Environmental Health Review Comments

AL2618: 7025 Franciville Rd - ALQ Permanent Occ

zoning of ALQ RR-5 zoning
7025 Francerville Rd 80908

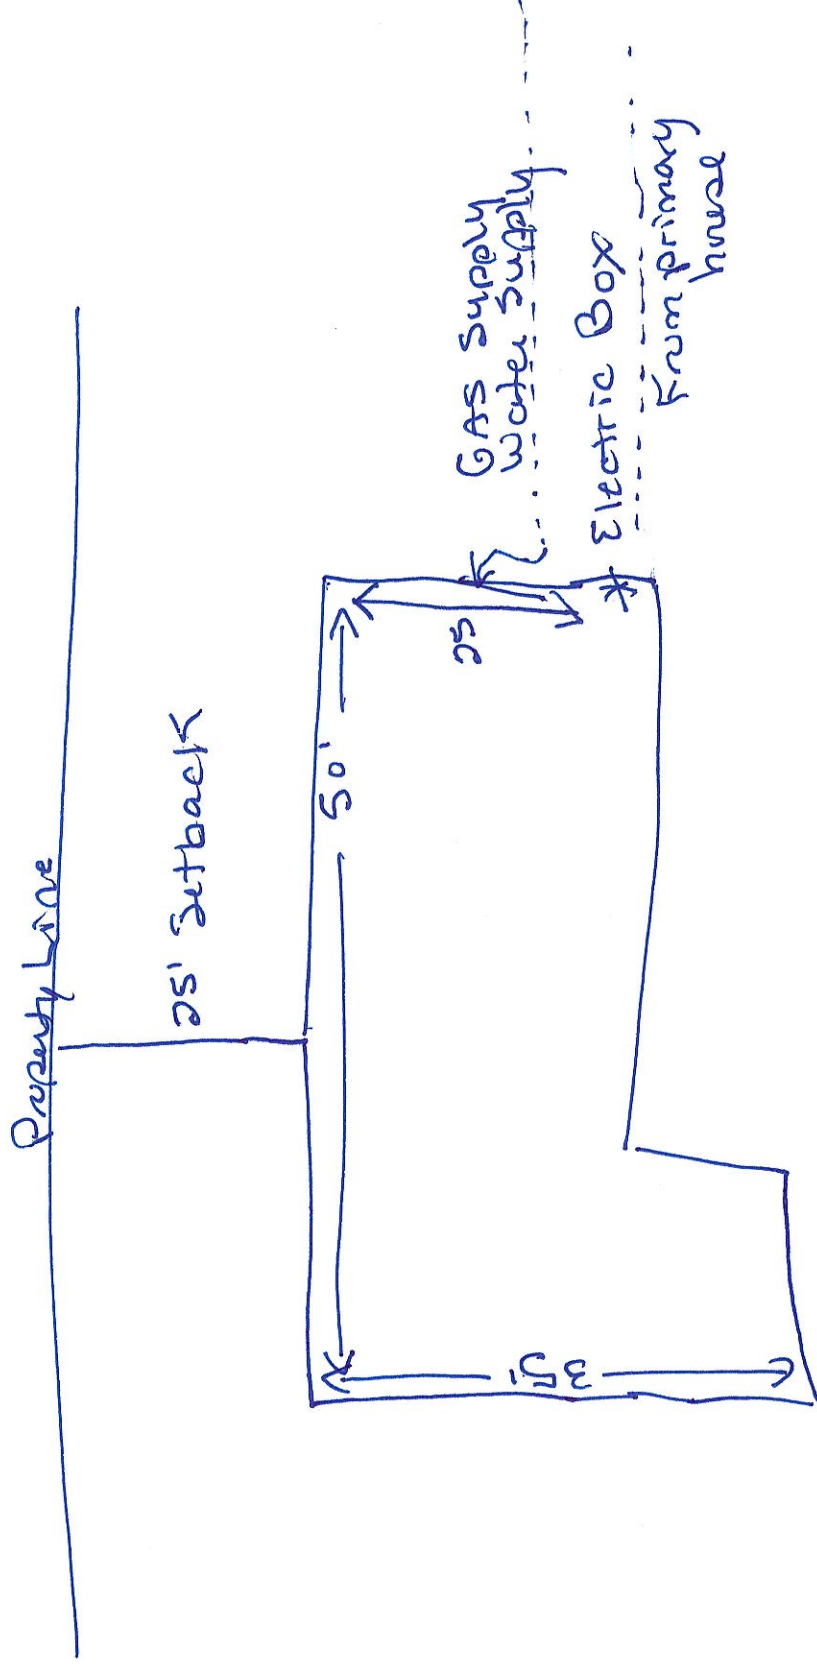
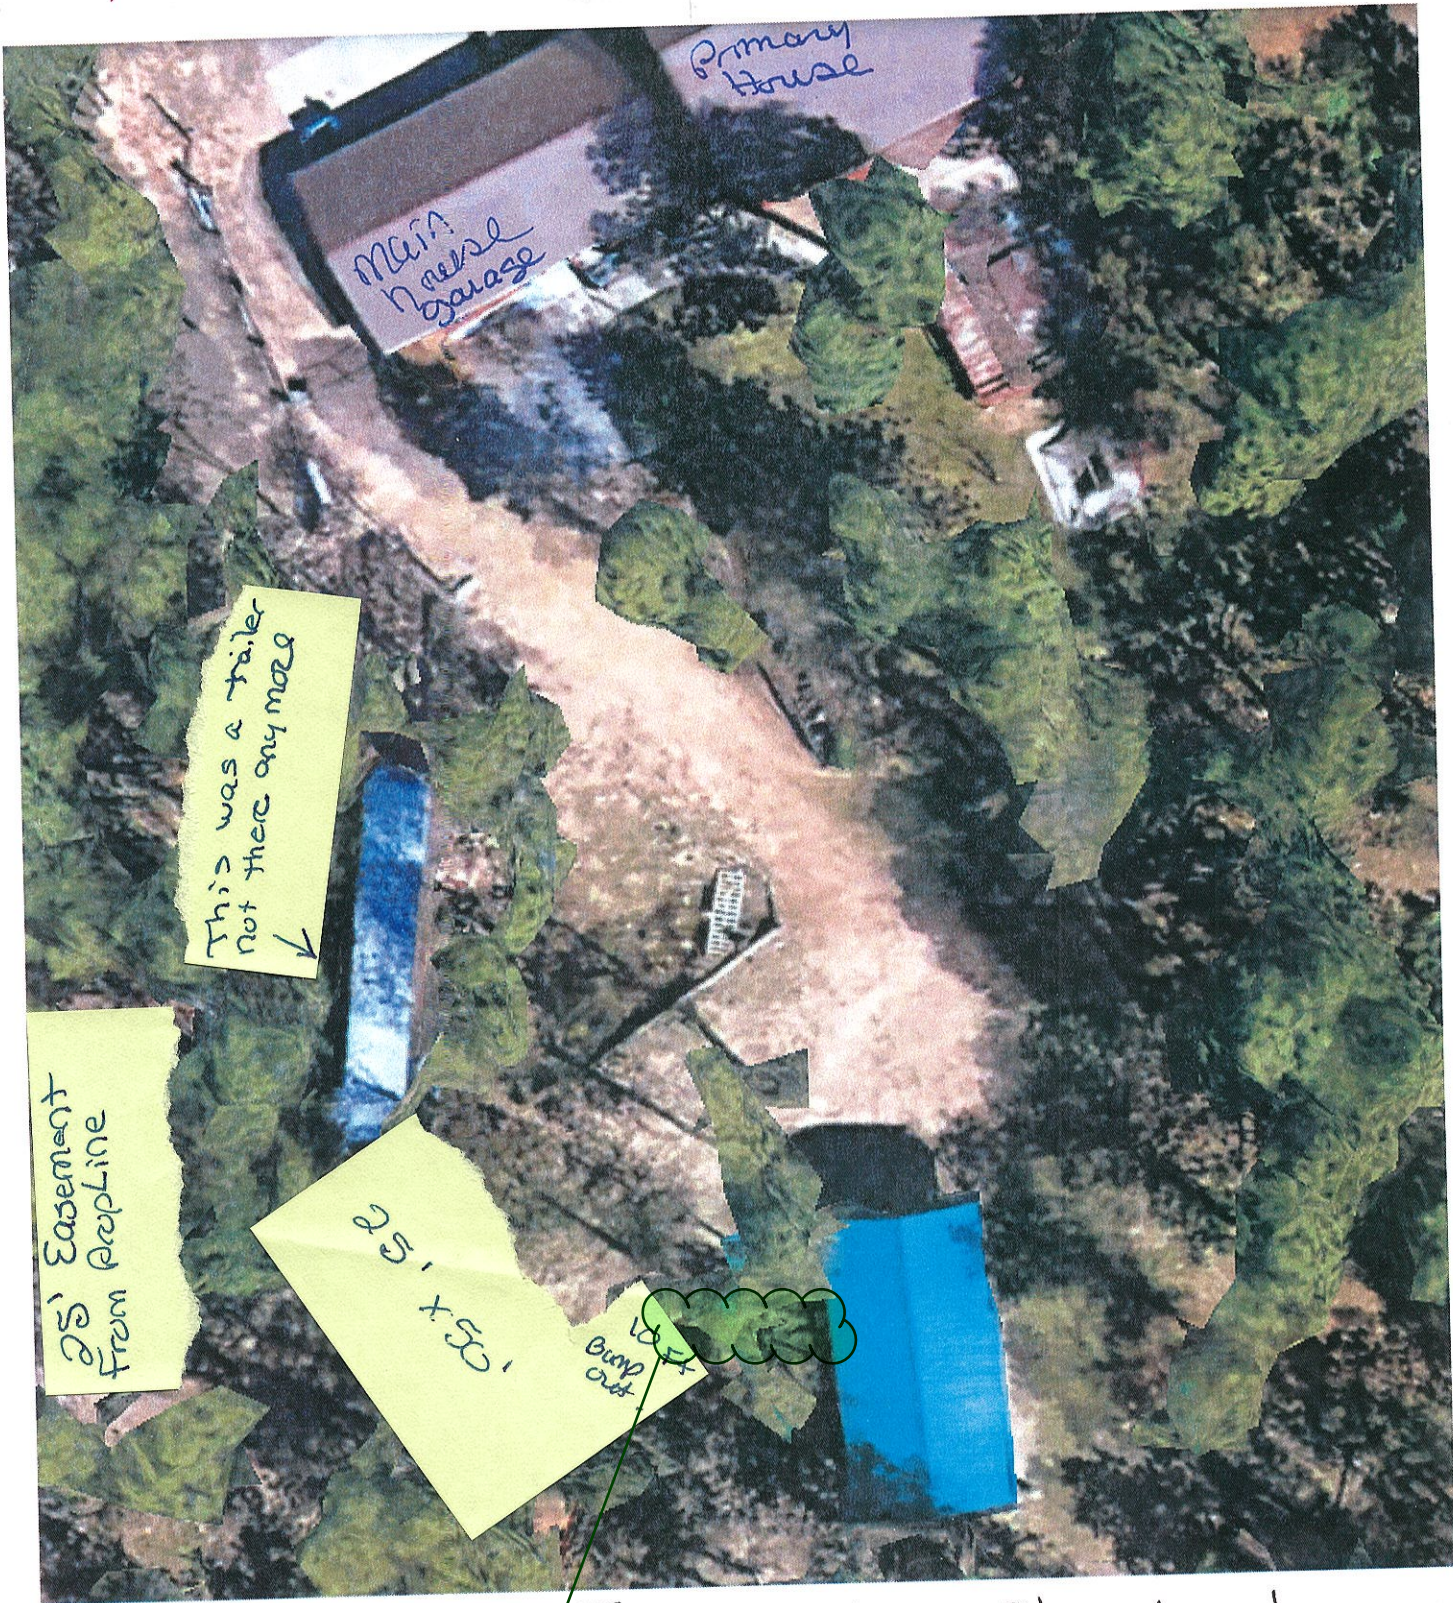
- Water service for the primary residence and the Accessory Living Quarters (ALQ) will be provided by a shared individual private well.
- Wastewater service for the project is proposed to be provided by an onsite wastewater treatment system (OWTS). The property has existing buildings served by existing OWTS systems based on the site plan a separate system is proposed for the ALQ:

- A New OWTS permit will be required by EPCPH for the new additional structure(s). Full compliance with Chapter 8 of the Board of Health Regulations governing Onsite Wastewater Treatment Systems in effect at time of submission is required. Minimum OWTS installation setbacks must be maintained both internal and external to the property lines.

- It is imperative that the STA location be protected from construction related activity to minimize the chance of construction equipment compacting the soil. Suggest marking the STA location to raise awareness of the area.
